24th May 2024

**TOWN AND COUNTRY PLANNING ENVIRONMENTAL IMPACT ASSESSMENT REGULATION 2017 (AS AMENDED) AND TOWN AND COUNTRY PLANNING ACT 1990
APPLICATION NO. 22/01340/OUT
APPLICANT'S NAME TRITAX SYMMETRY ARDLEY LTD
PROPOSAL: APPLICATION FOR OUTLINE PLANNING PERMISSION (ALL MATTERS RESERVED EXCEPT MEANS OF ACCESS (NOT INTERNAL ROADS) FROM B4100) FOR THE ERECTION OF BUILDINGS COMPRISING LOGISTICS (USE CLASS B8) AND ANCILLARY OFFICES (USE CLASS E(G)(I)) FLOORSPACE; ENERGY CENTRE; HGV PARKING; CONSTRUCTION OF NEW SITE ACCESS FROM THE B4100; CREATION OF INTERNAL ROADS AND ACCESS ROUTES; HARD AND SOFT LANDSCAPING; THE CONSTRUCTION OF PARKING AND SERVICING AREAS; SUBSTATIONS AND OTHER ASSOCIATED INFRASTRUCTURE.
LOCATION: OS PARCEL 6124 EAST OF BAYNARDS GREEN FARM, STREET TO HORWELL FARM, BAYNARDS GREEN PARISH(ES): STOKE LYNE**

Please find enclosed an amended planning application submission, including an Environmental Statement Addendum which has been prepared to address changes that have been made to the plans for Symmetry Park, Ardley, and additional information in response to comments received on the scheme since submitted.

Drawing Name:
PARAMETERS PLAN

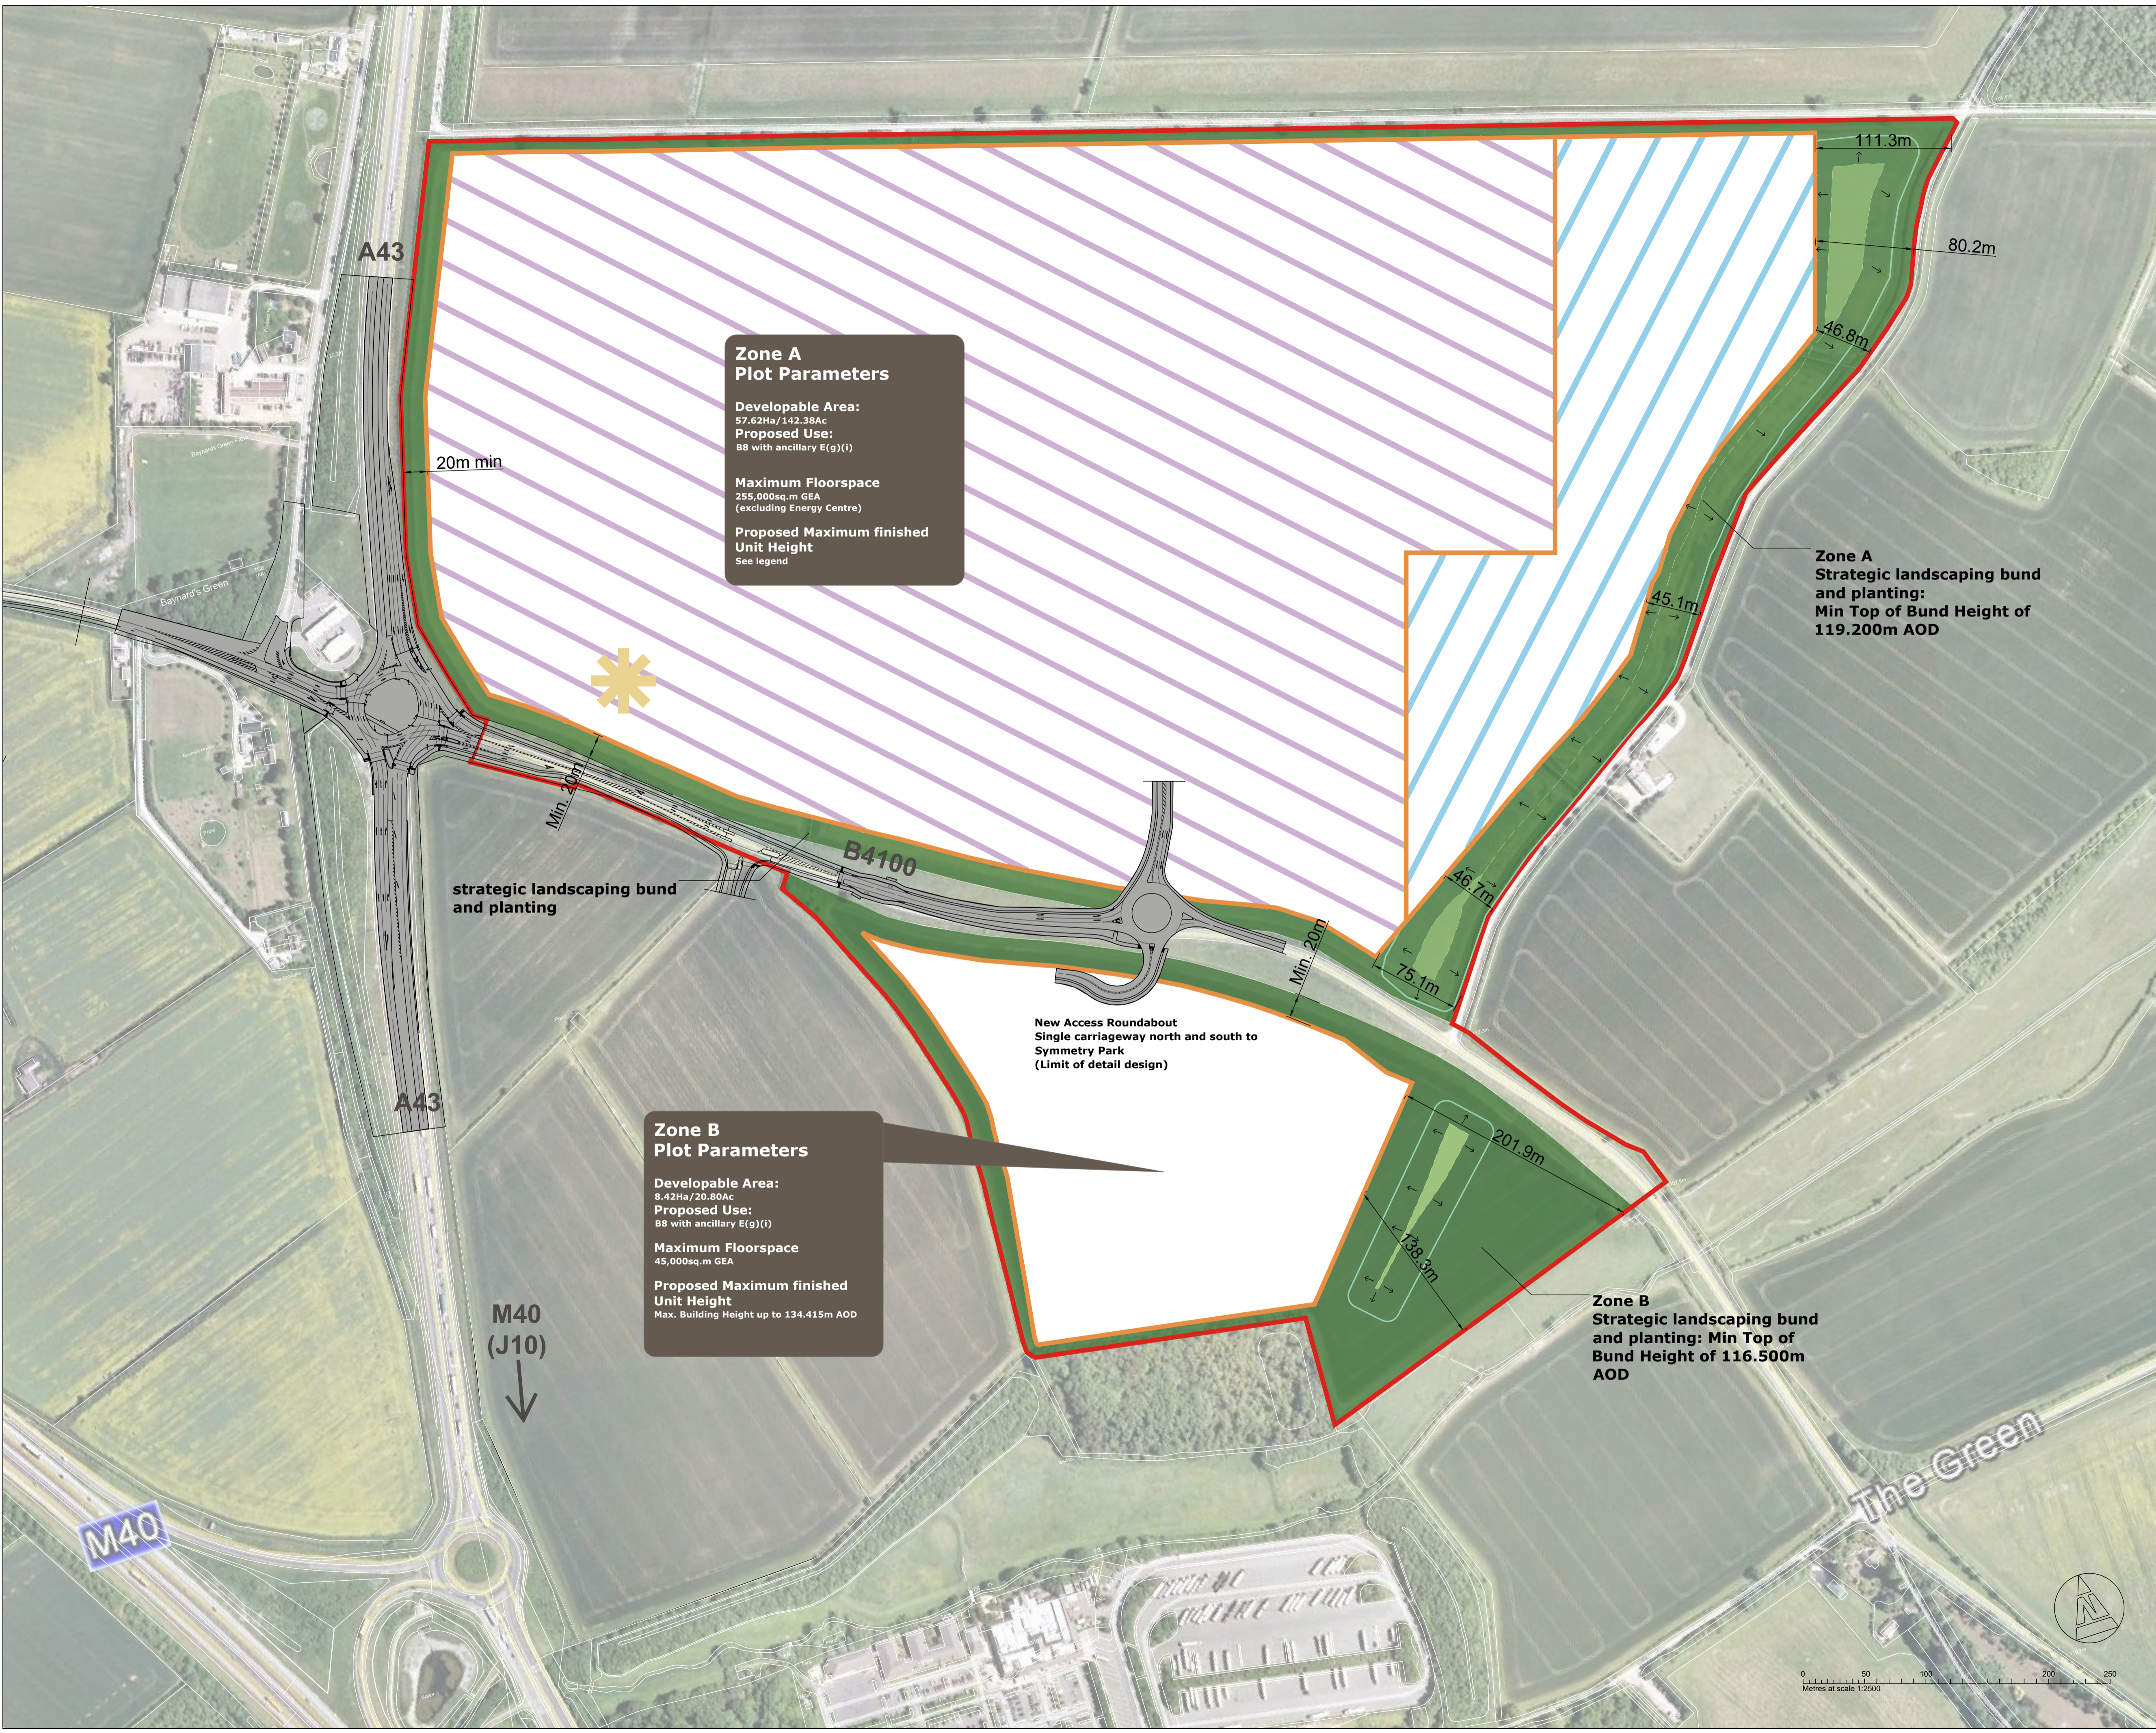
- Amendments to the heights of the proposed development. The proposed unit heights are: Building heights: Overall, the main built structures would be up to a maximum of 140.350 m AOD in Zone A1; 137.350 m AOD in Zone A2; and a maximum of 134.415 m AOD in Zone B;

- Amendments to the strategic landscape bund and planting along the eastern boundary: as a result of the assessment, the developable area was moved away from the boundary, resulting in a minimum buffer distance from the eastern planning boundary of 45.100m (Zone A).

- The strategic landscape bunds having been increased in height, with minimum heights now proposed. The strategic landscape bund in Zone A has a minimum top of bund height of 119.200 m AOD and in Zone B minimum top of bund height of 116.500 m AOD. There is a minimum buffer distance from the eastern planning boundary of 45.1m.

In summary there have been changes to the Parameter Plan, including the area shown for proposed development is positioned further back from the eastern boundary, with a corresponding increase in the width of the landscaping; further details of the earth bund proposed along the eastern boundary; and a reduction in overall building heights on the eastern and southern areas.
